BAYSIDE COUNCIL SUBMISSION SSD-9691 – ORICA SOUTHLANDS WAREHOUSE ESTATE

Council's Submission on SSD-9691

Council understands that consent for the following development is now sought:

'A warehouse and distribution facility including the construction of two warehouse buildings, ancillary office space and hardstand/car parking areas on an elevated concrete platform above the flood storage area.'

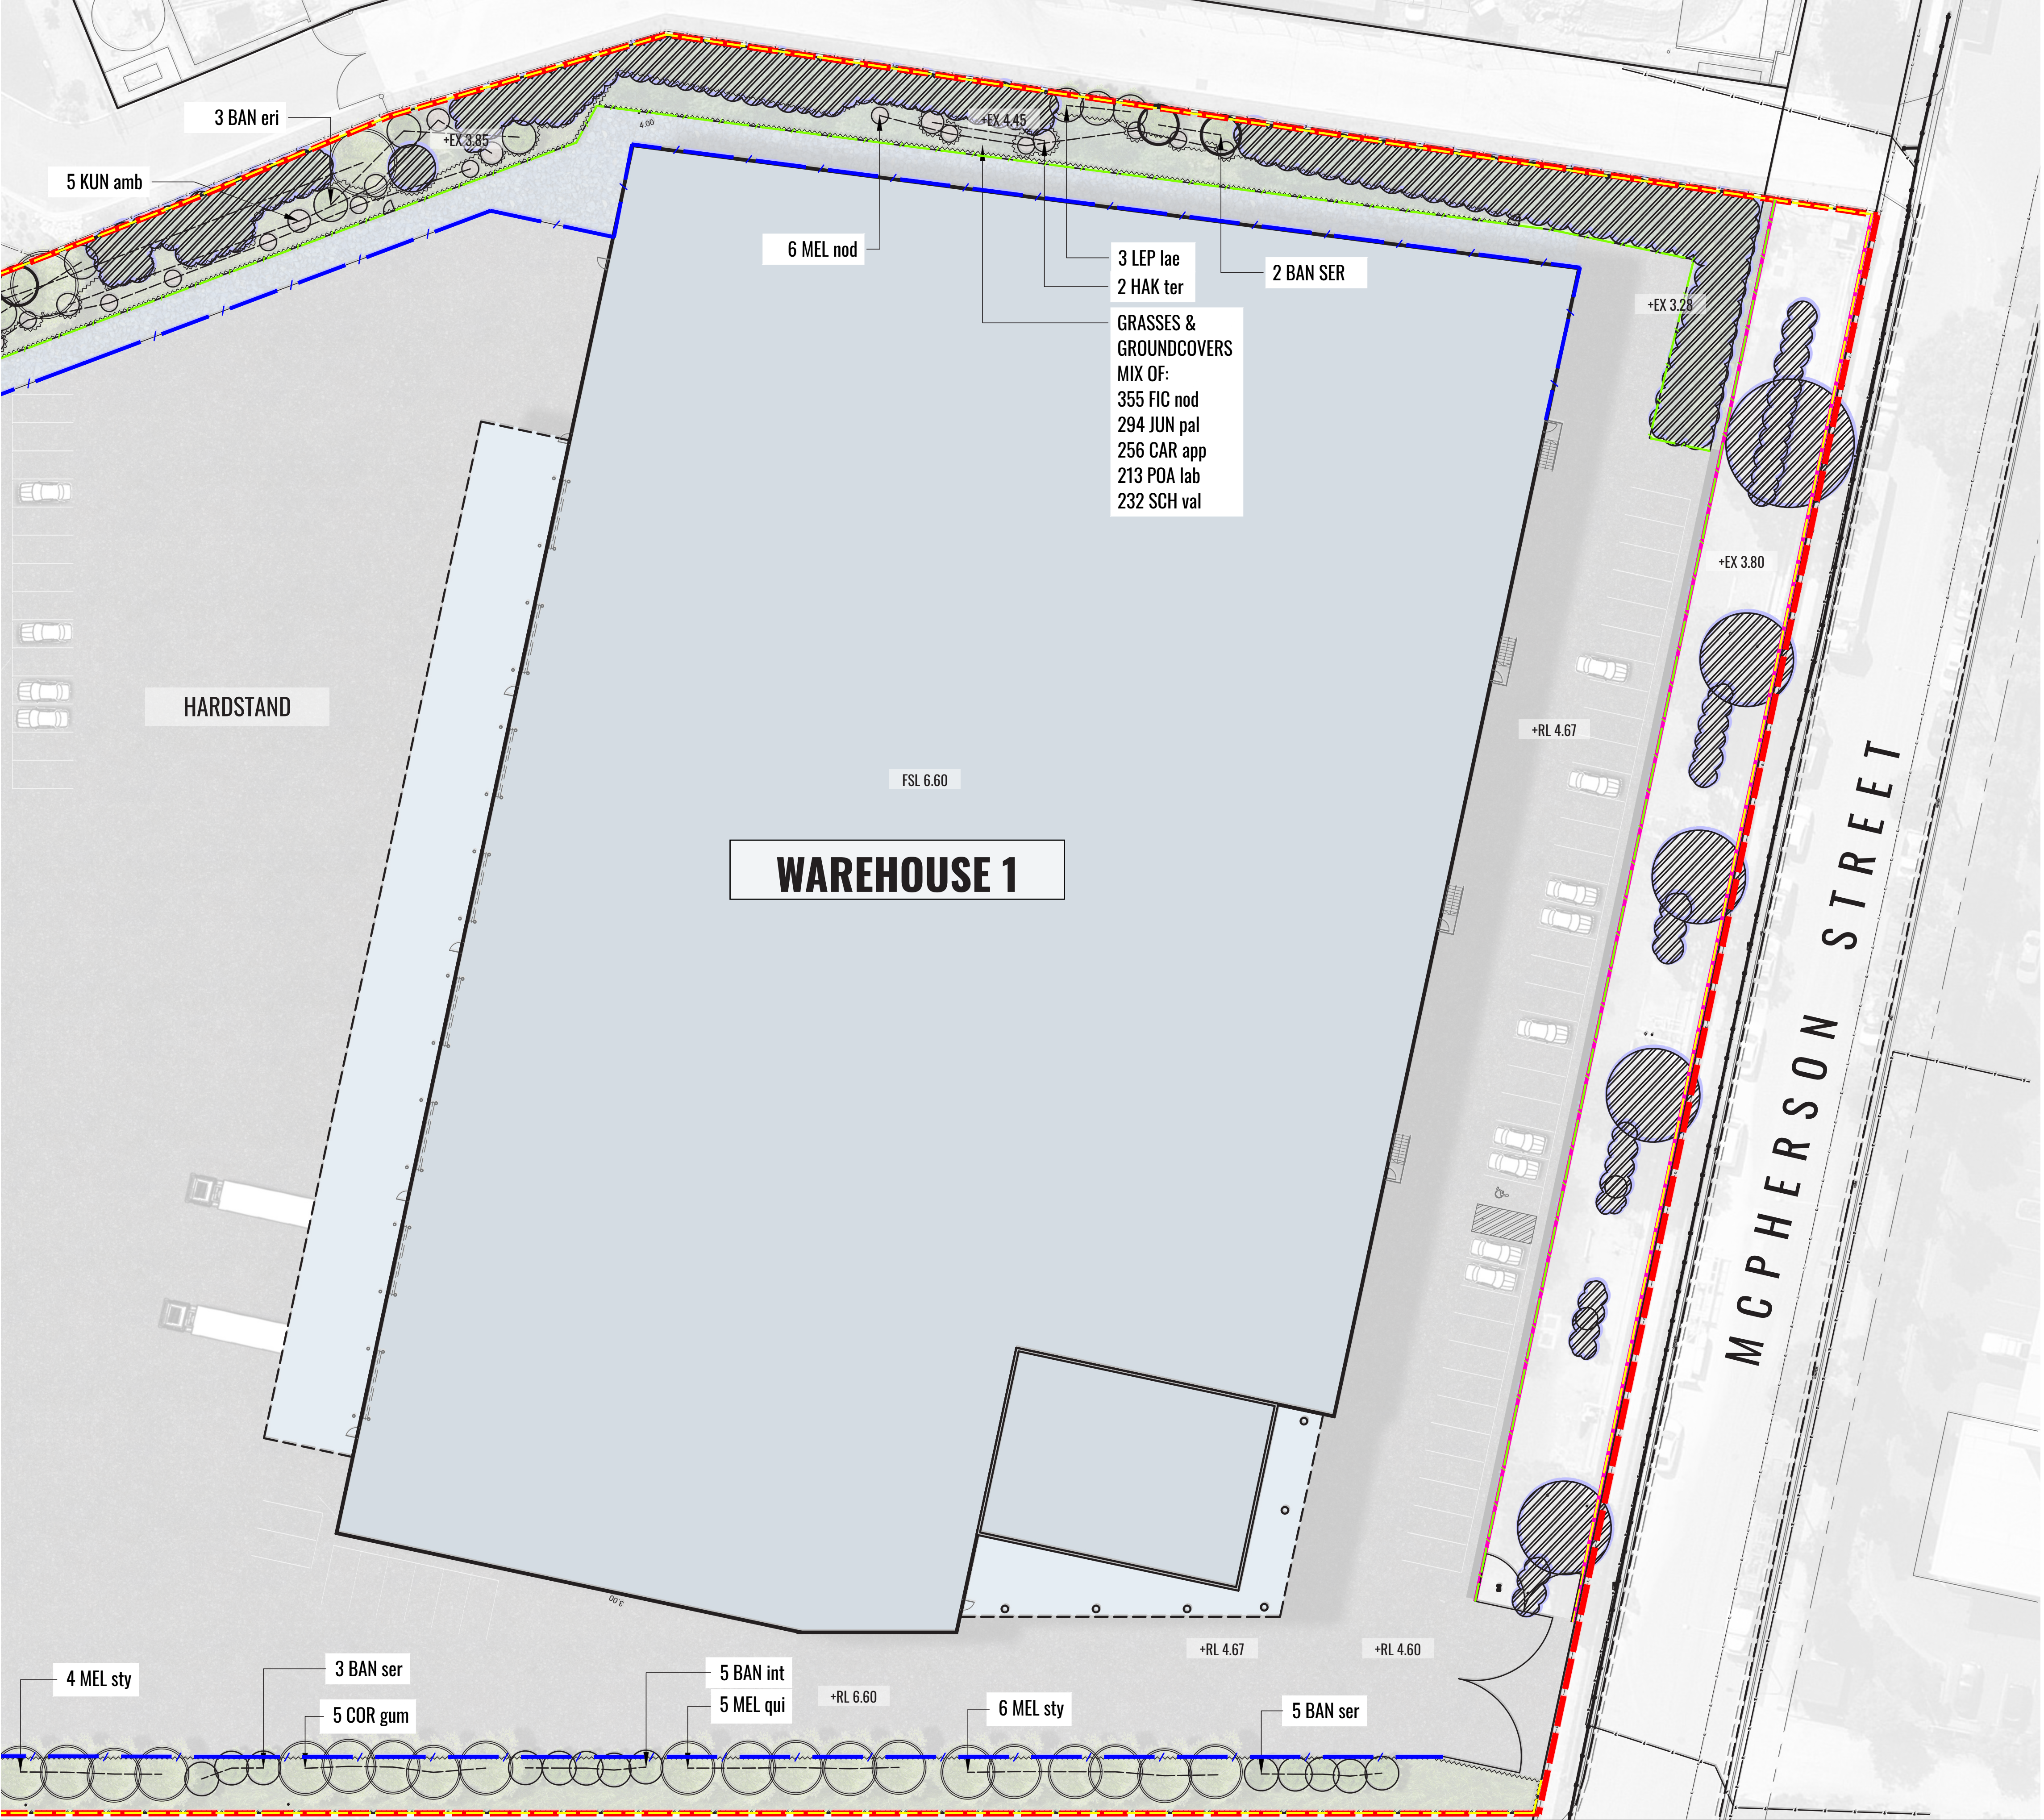
- A copy of the music model, hydraulic and flood assessment model shall be provided to Council for record.
- Fence and landscaping:
 - The proposed landscaping and black mesh fence adjacent to Nant Street have the potential to block overland flow into the undercroft of the building. The western site boundary must be maintained largely open (appropriate open form fencing – pool fencing) to ensure the floodwaters can pass unimpeded into the undercroft area. This will require appropriate planting and fencing and an ongoing maintenance regime to minimise vegetation growth.
